Explore Academy

This letter outlines the modifications that have been made to the Explore Academy application to amend their site development plan (PR-2020-004708) to address the agency comments that were received.

B4 PH3B CIRCULATION DIAGRAM
NTS

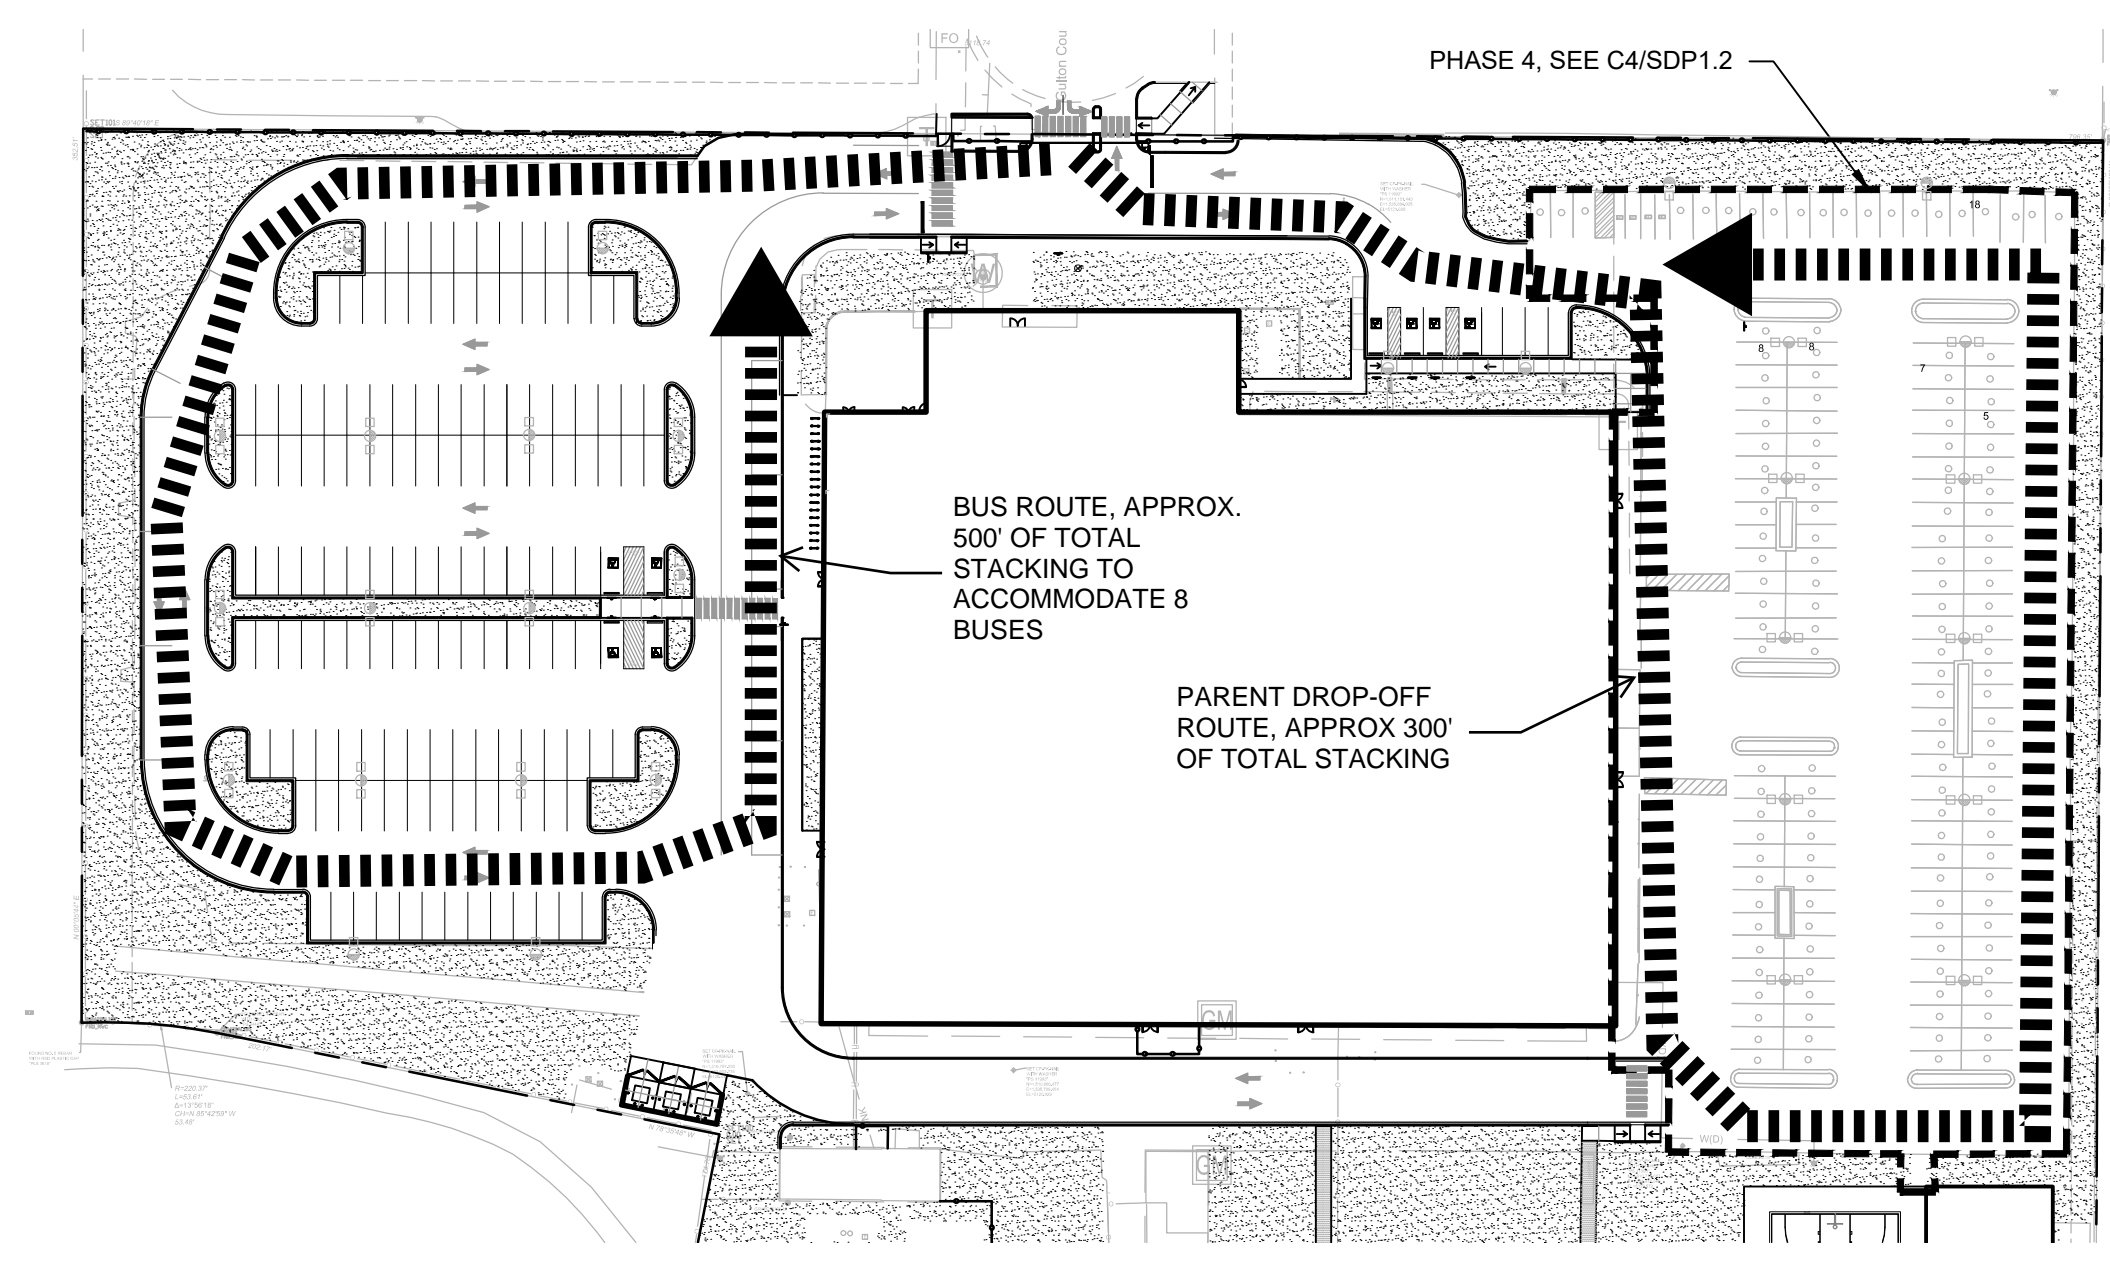
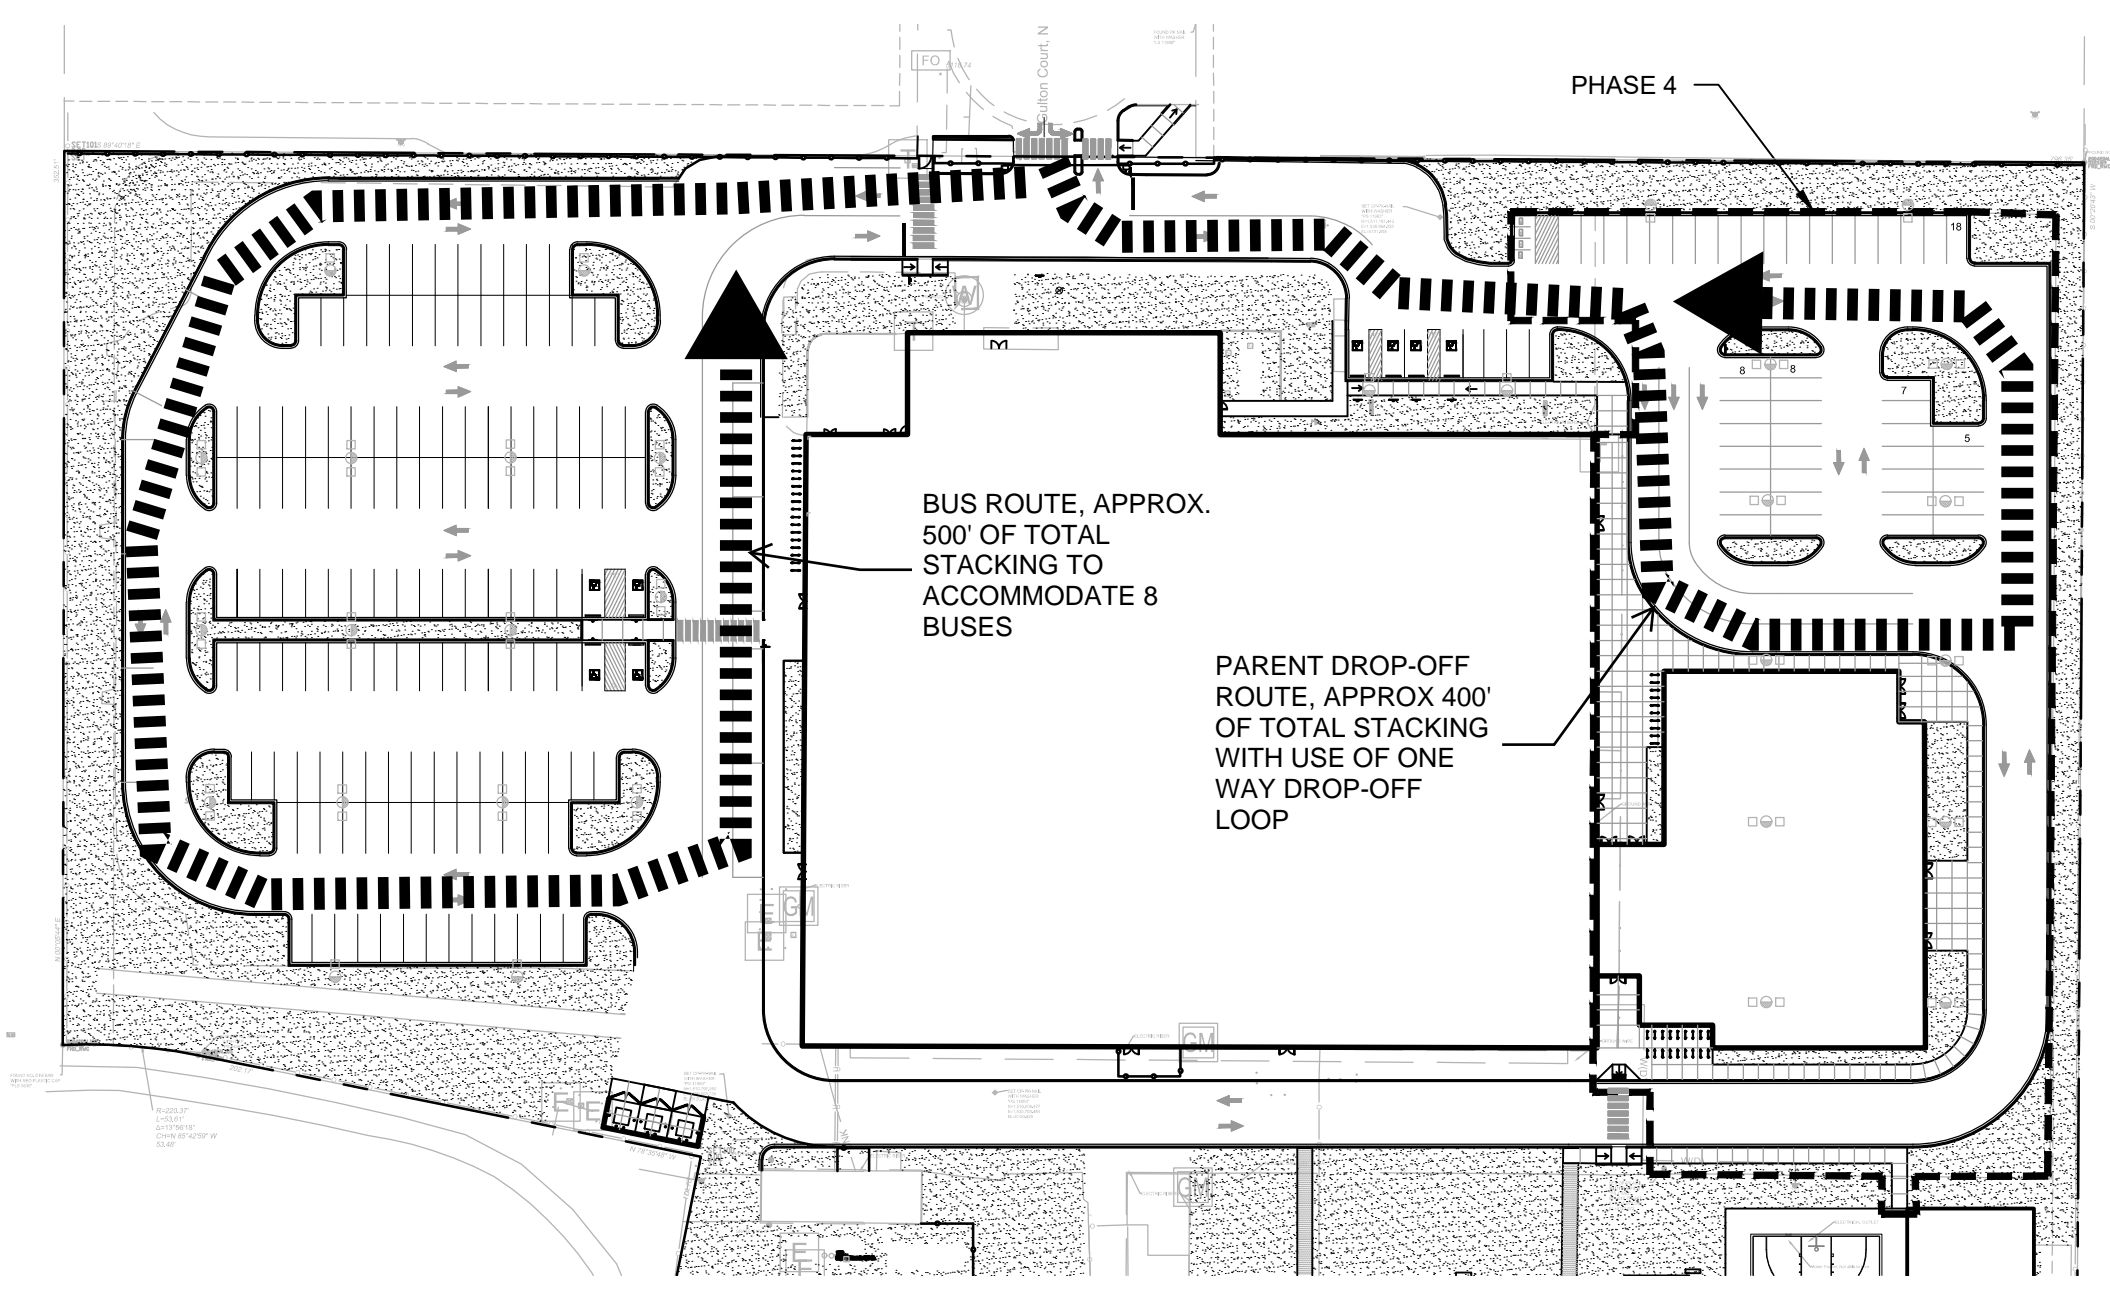
2. Show queuing pattern for bus drop-offs and parent drop-offs. It shall be demonstrated that the queuing can be contained within the site and follows a smooth, efficient pattern. How many buses will be used and what are the hours of operation?

Queuing pattern for bus and parent drop-offs is indicated on B4/SDP1.2 and C4/SDP1.2.

C1 BICYCLE RACK
NTS

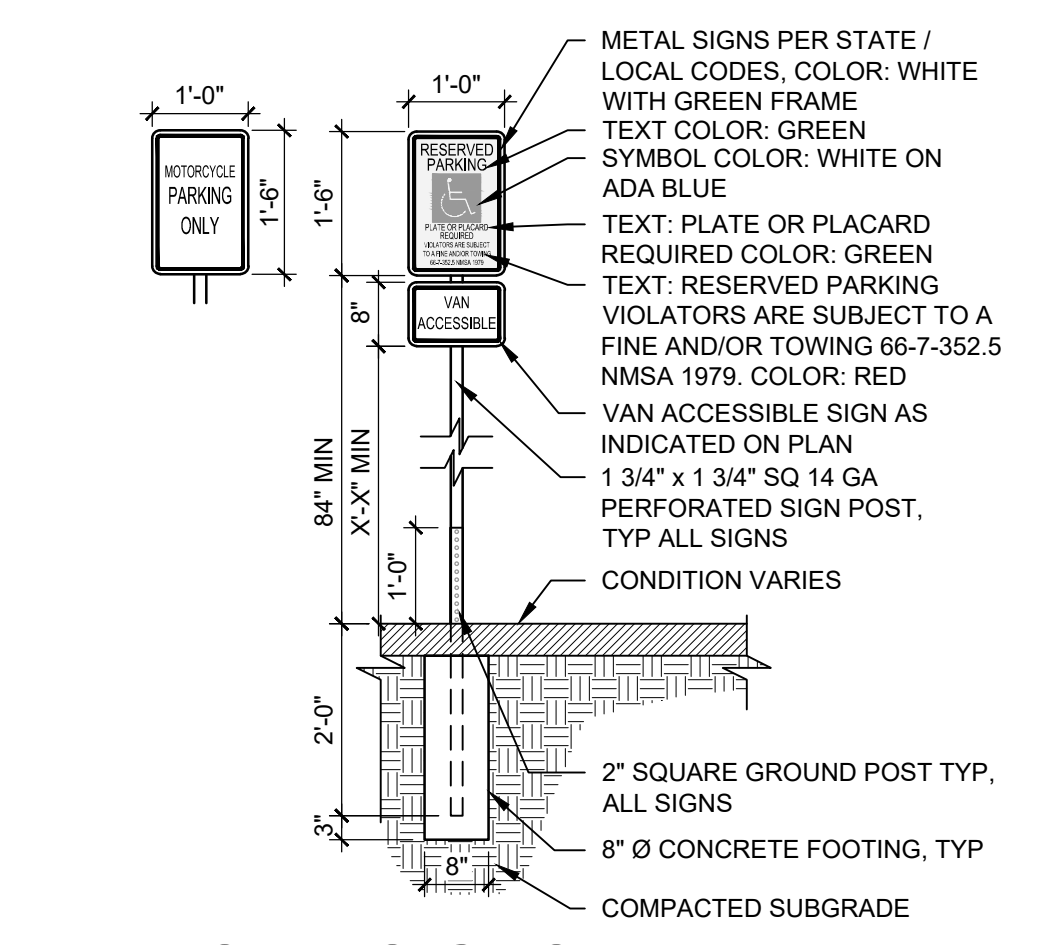
6. Bike rack detail shall meet IDO standards.

Bike rack has been replaced with a style that meets IDO standards.

SHEET NO.
SDP1.1
OF

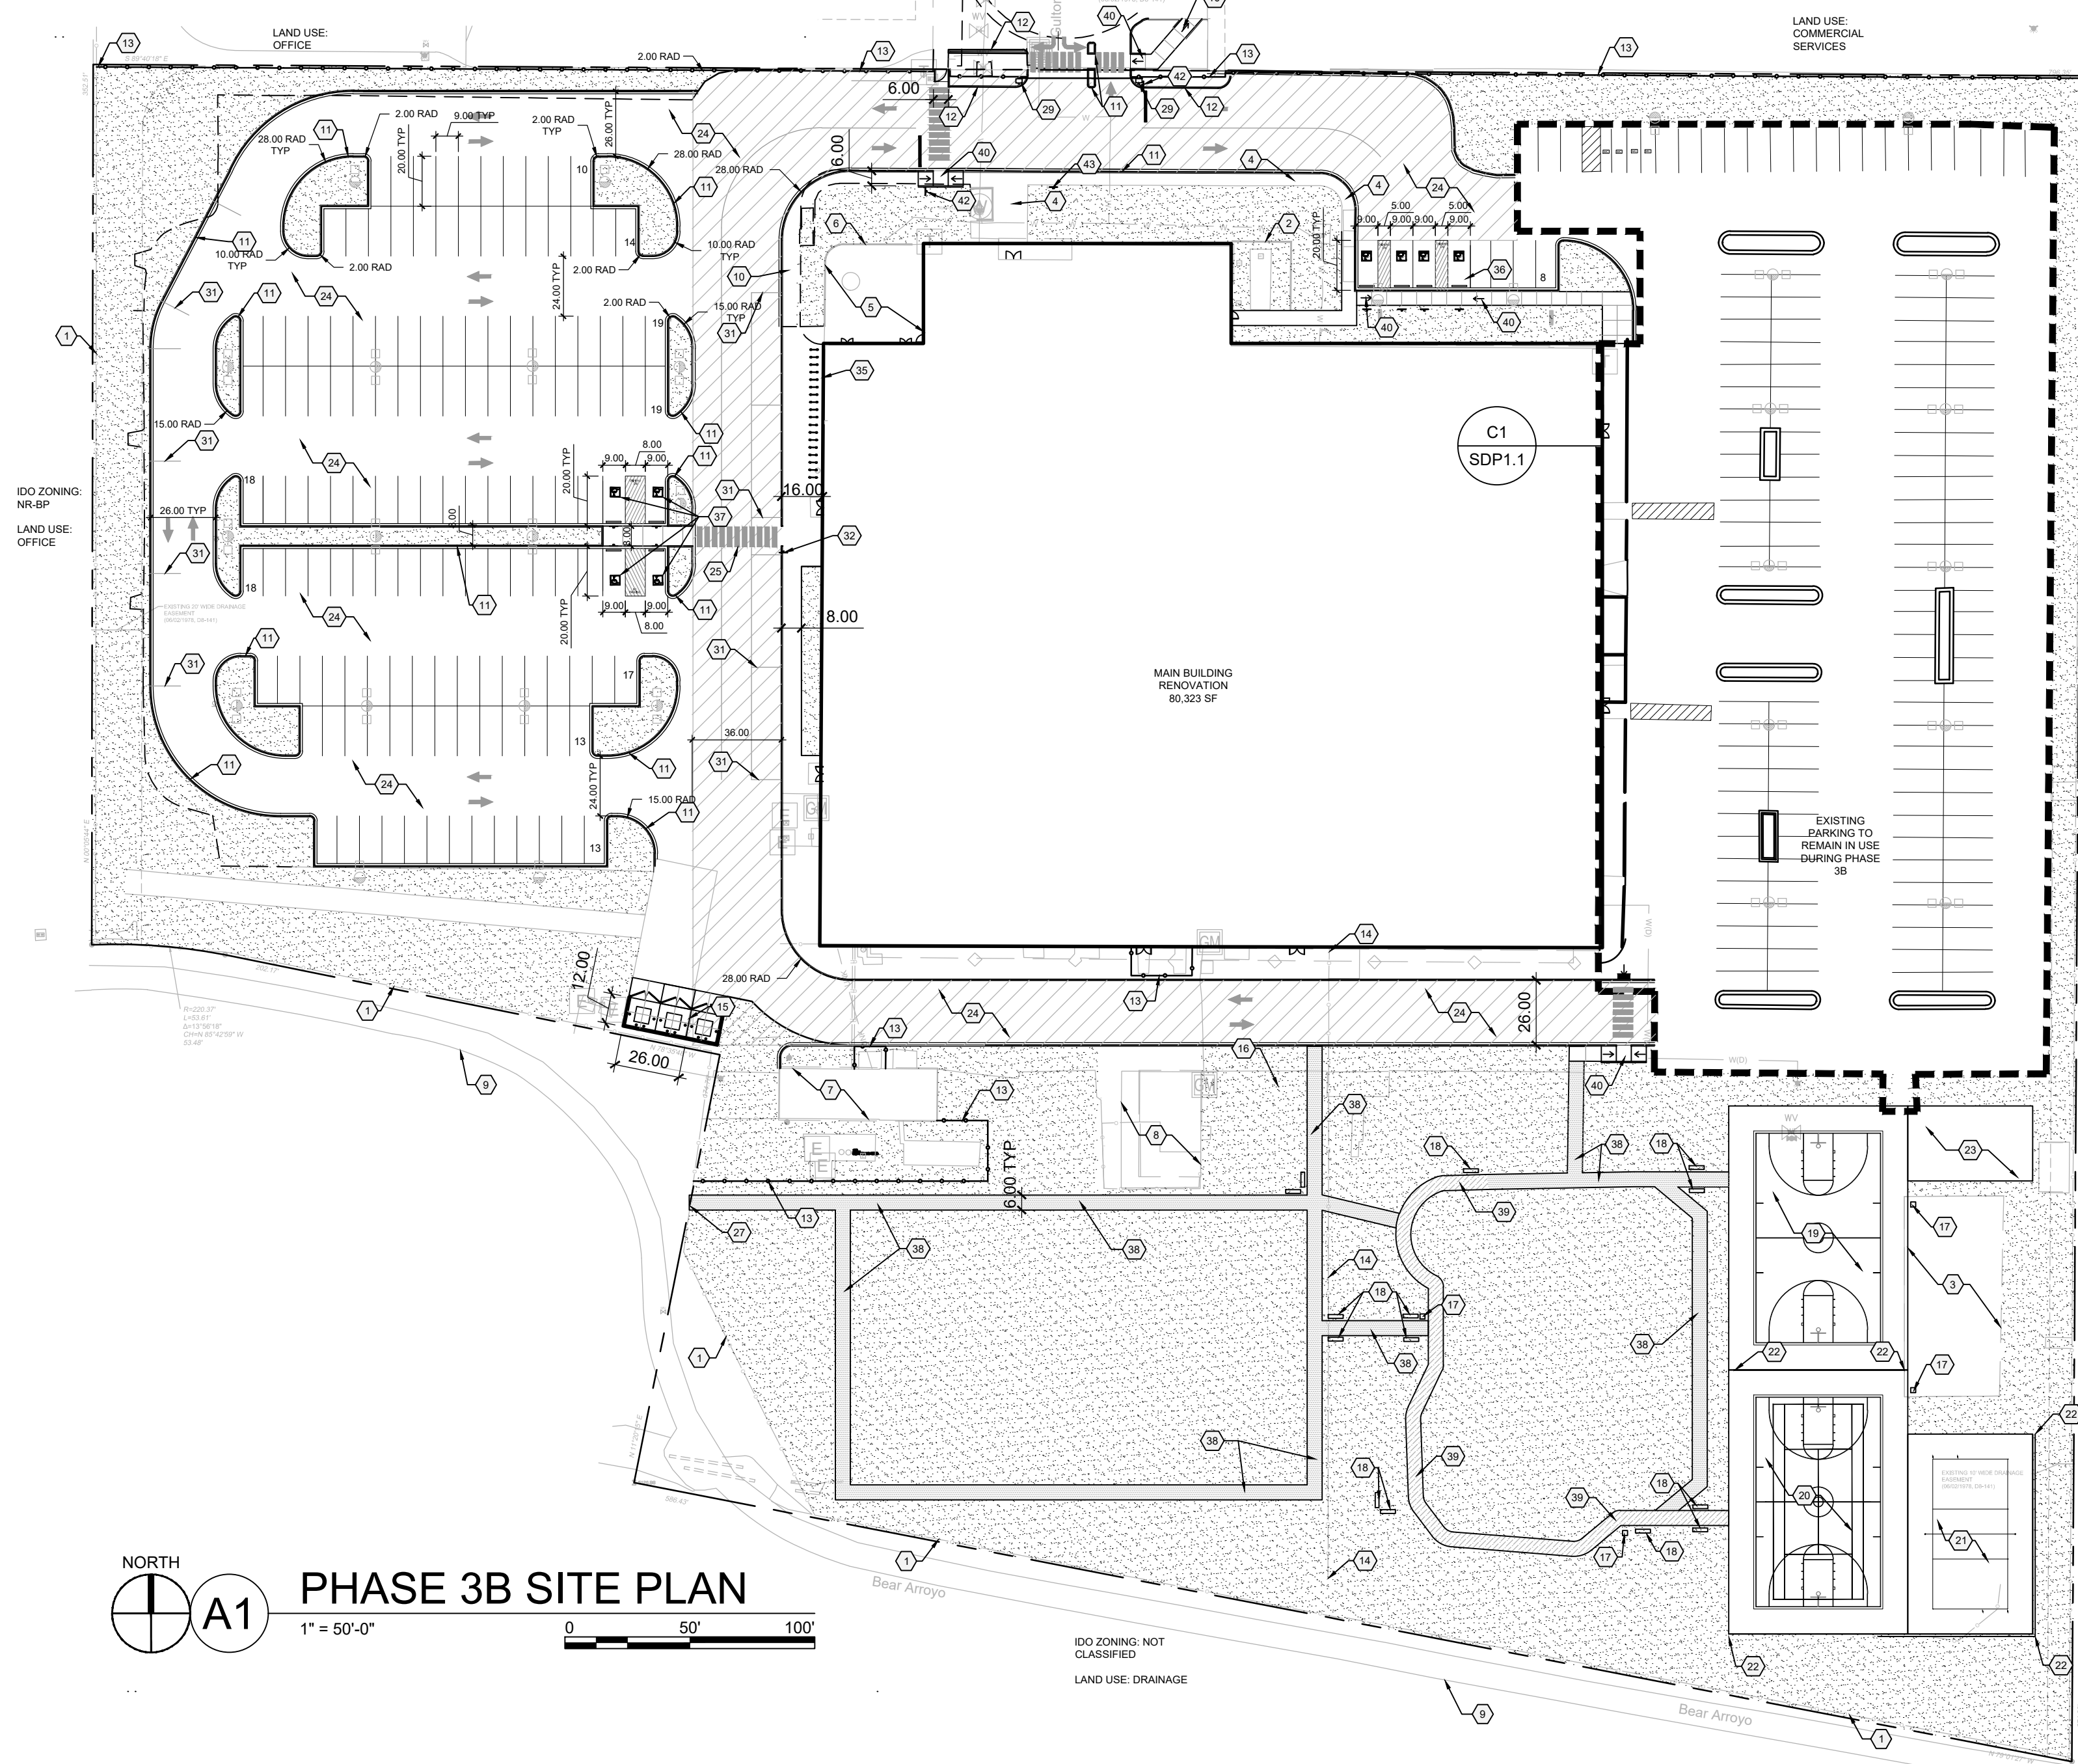
1. Phase 4 of the Site Plan proposes a 16,450 square foot gym addition onto the existing building on the Site. Table 5-5-1 of the IDO requires that parking for a High School have 1 parking space per 4 seats in the main auditorium or 3 spaces per classroom, whichever is greater. However, the Site Plan only lists the calculation for the number of spaces per classroom. The Site Plan only lists the calculation for the number of spaces per classroom. The Site Plan must include the calculations for the required number of parking spaces per seats in the main auditorium, which would be the proposed gym, in addition to the required number of parking spaces per classroom and determine which is greatest (which would determine the number of required parking spaces).

2. It appears that sidewalks/pedestrian walkways are proposed south of the main building, but there is no note of them on the Site Plan. The proposed sidewalks/pedestrian walkways need to be noted on the Site Plan.

3. Any striping for the bus drop-offs shall be labeled. Include signs to not obstruct the pedestrian path to the west of the school.

4. List curb height and all curb radii within parking lot. Also dimension all parking aisles and all parking spaces, including eth accessible parking spaces.

5. Dimension medians within parking spaces. If there are any compact spaces, call these out as "Compact."

10. Public sidewalk is required along site frontage on Gulton Court. Demonstrate sufficient right-of-way for the sidewalk. Verify what is being done within right-of-way at Gulton Court.

Revised calculations are included and the greater number which came from the auditorium calculation is being utilized.

Previously called out with legend, now using keyed notes for clarity.

Striping has been labeled and the above-mentioned sign has been added.

This annotation has been added to the site plan.

Dimensions included. No compact spaces on the plan.

The site plan has been modified to reflect these changes.
